# SUNSET VILLAGE FILING NO. 4

## CONSTRUCTION PLANS

**CONSTRUCTION DRAWINGS AMENDMENT, DATED APRIL 4, 2026 BY ENGINEERING LOCAL XPERTS, LLC.**

POND A - SECTION 1
N.T.S.

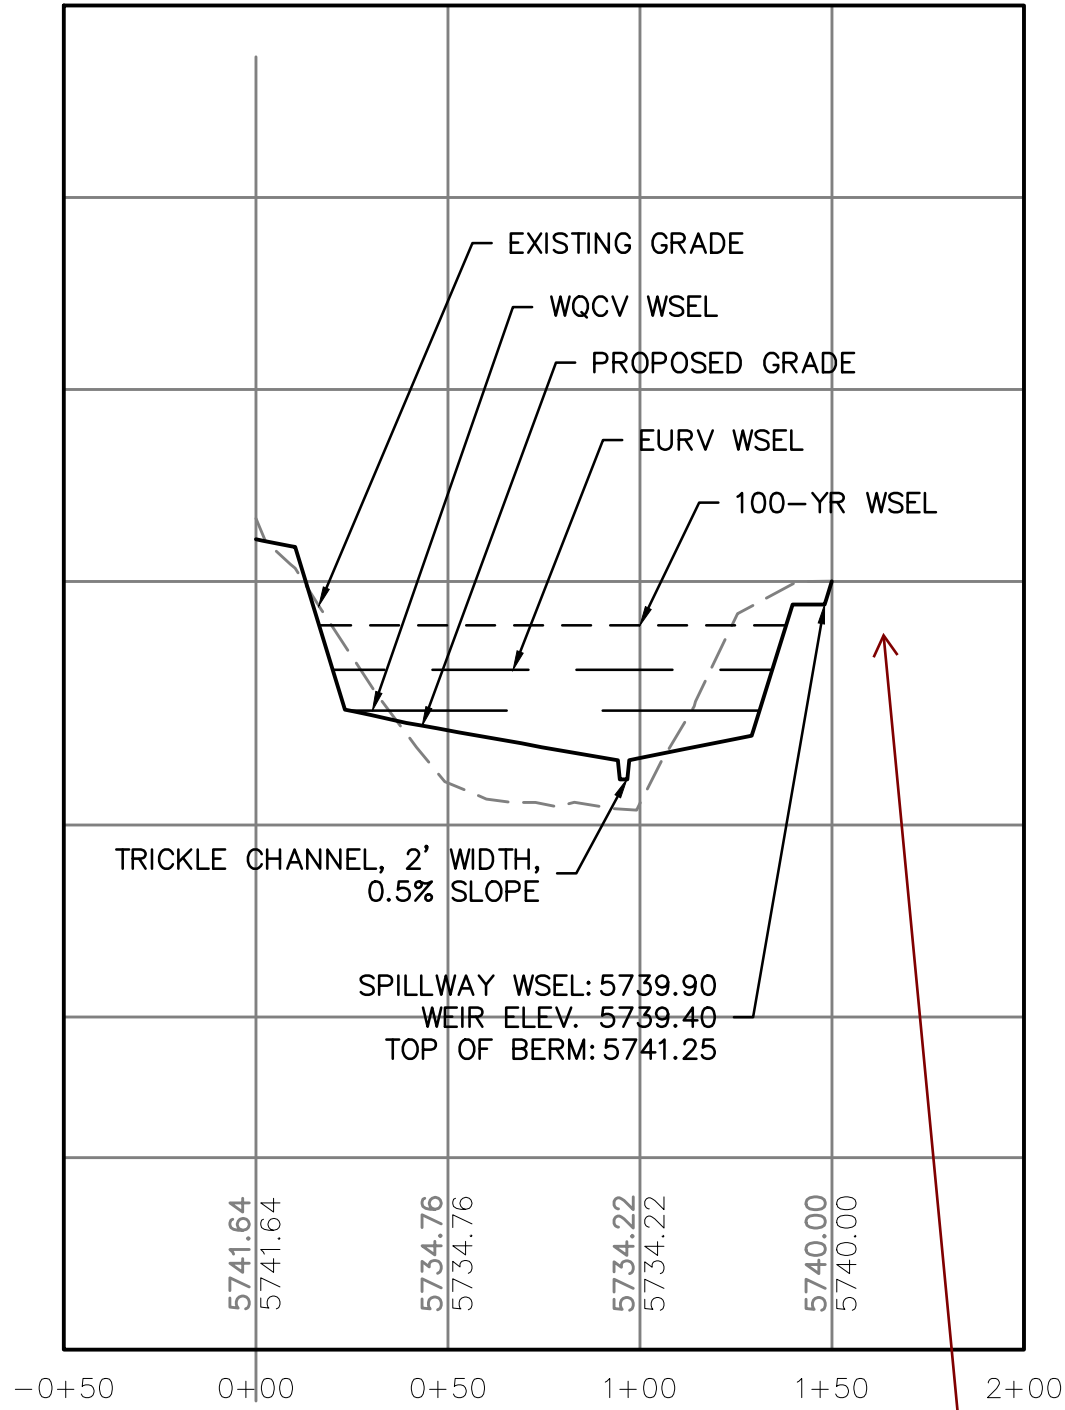
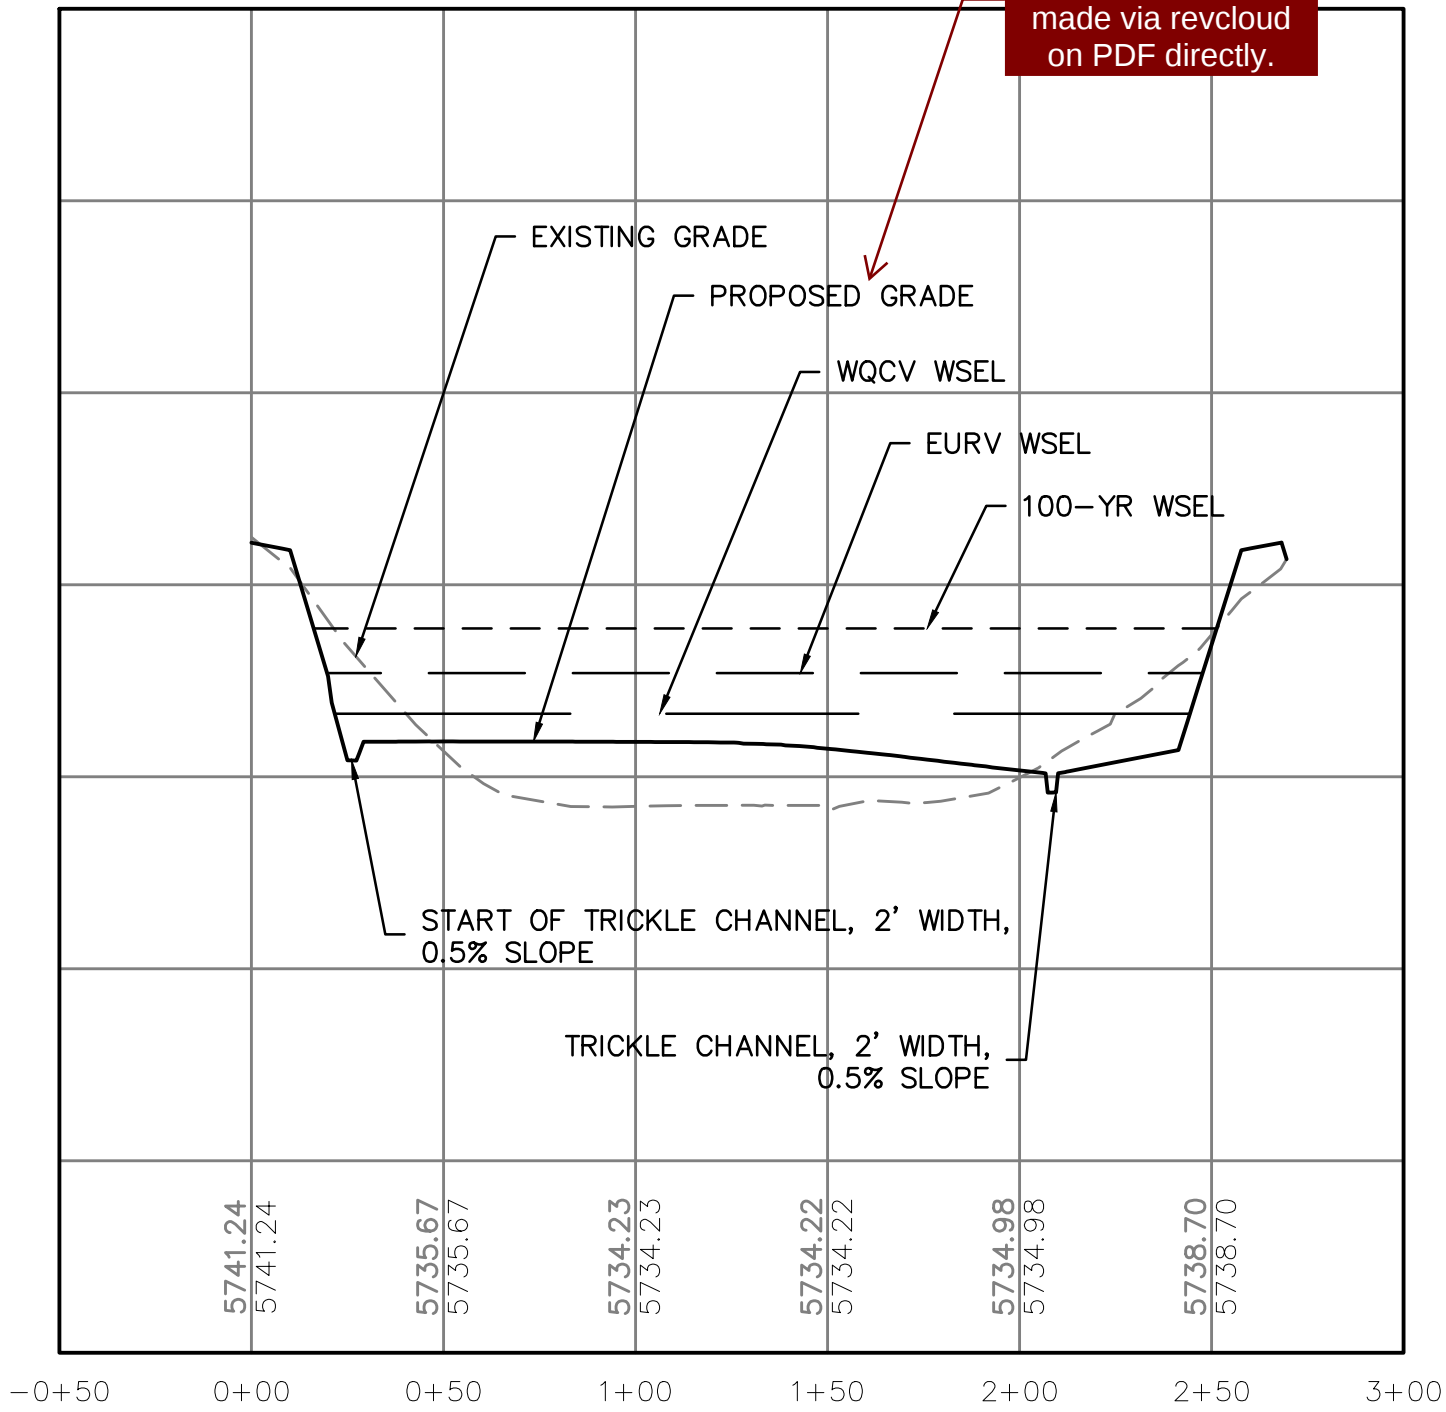
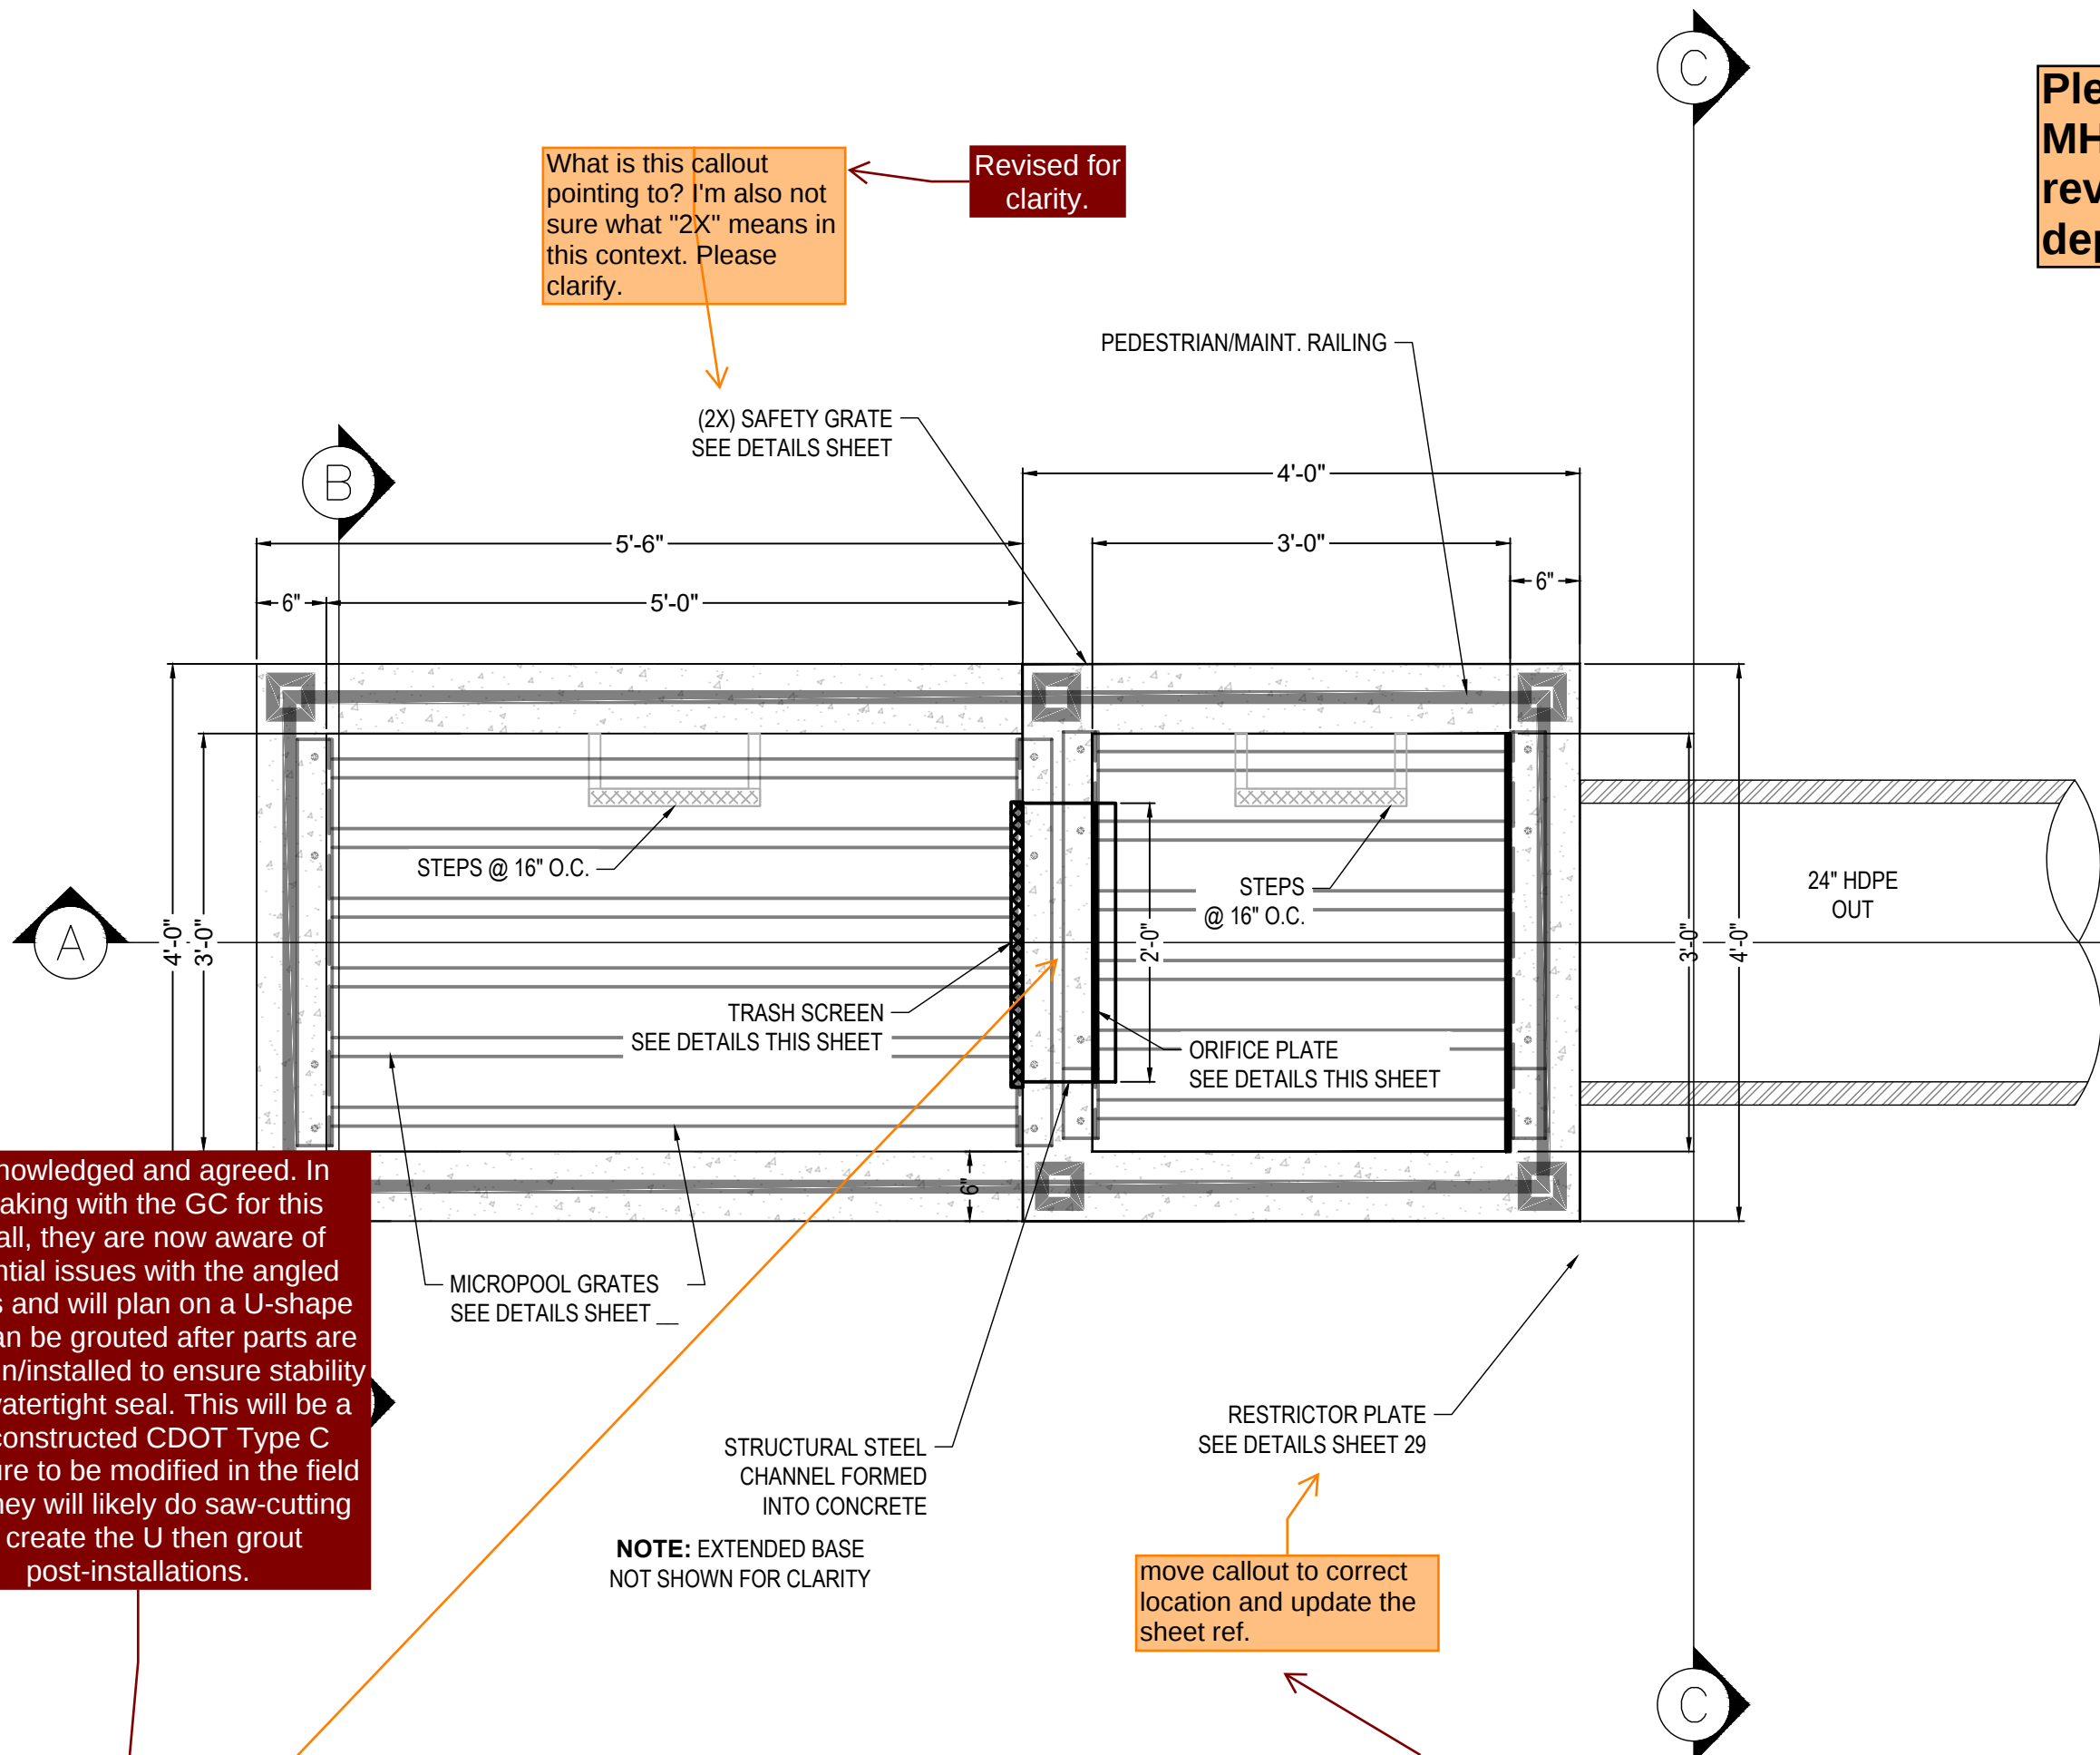
Please update the Pond 2 plan to be consistent with the revised pond outlet structure and forebay details shown on Sheets 20-22. Several elevations on the current Pond 2 sheet—including top of micropool, WQCV WSEL, EURV WSEL, and 100-year WSEL—do not match the updated design information.

Please update the pond summary table to reflect the revised pond design.
